Your Ref: OWPC16780
Our Ref: Y/75/17/HH 09-11-2017
Please ask for:
Mark Jones

Erection of first floor over existing side and rear extension.
7 Mill View Road Yapton

Thank you for your internet representation made on 1st January 2018 which has been recorded as '**an objection**' with the comments as follows:

BLOCK PLAN

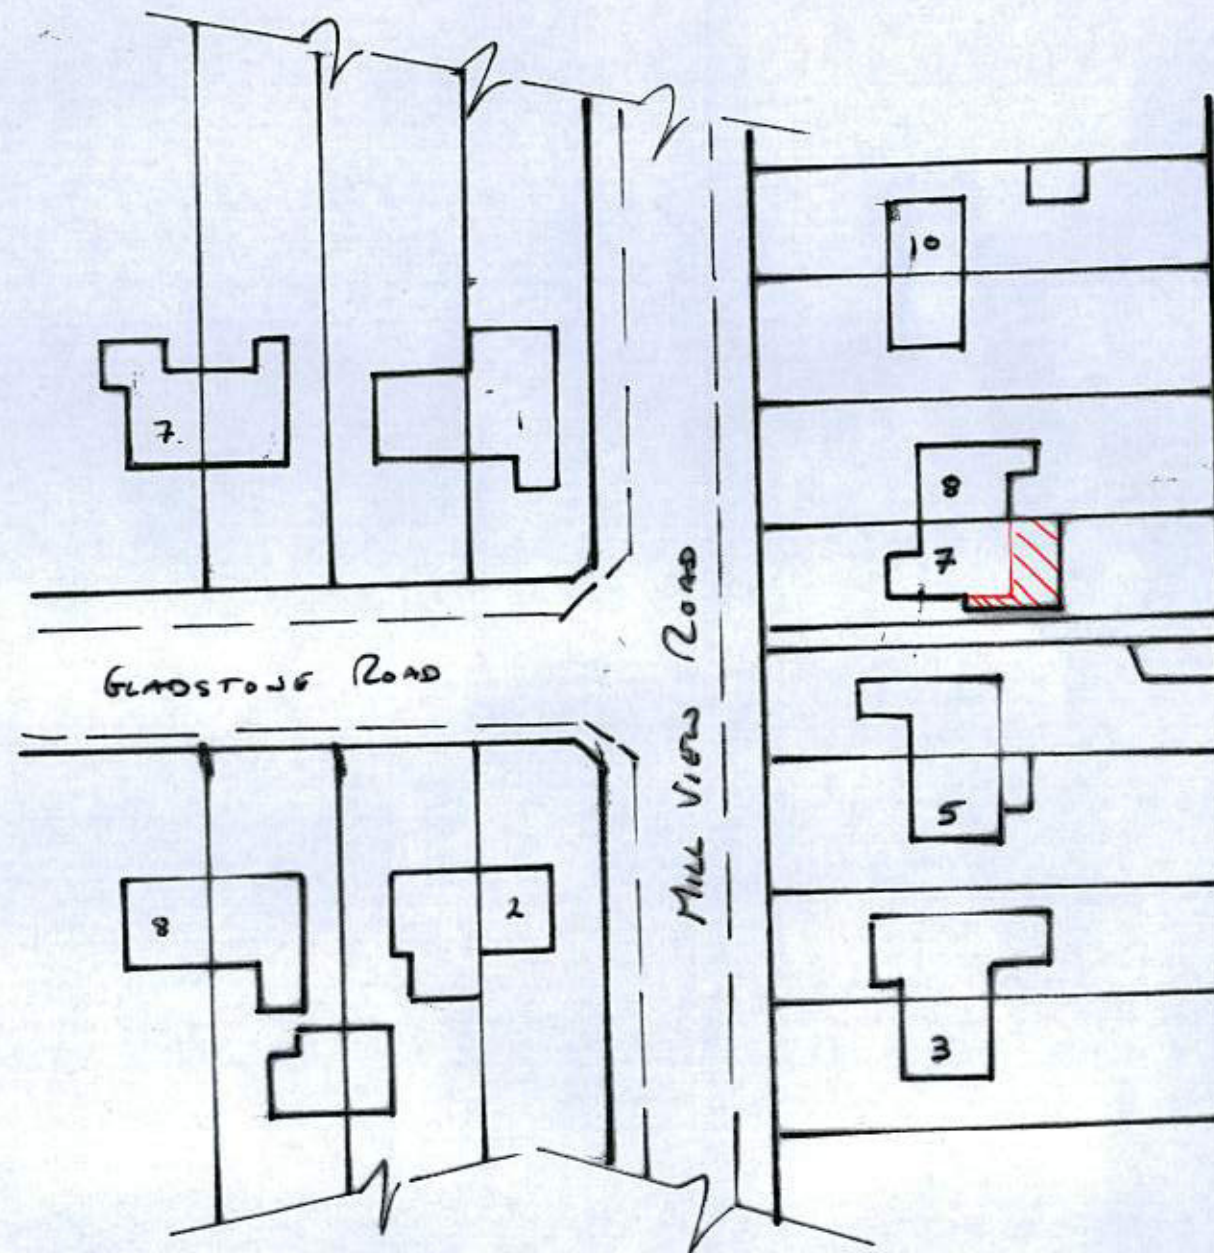
The Block Plan drawing showing distances to boundaries is incorrect. As the existing ground floor extension extends to the boundary line the proposed extension will not be 200mm from the boundary as shown on the drawing.
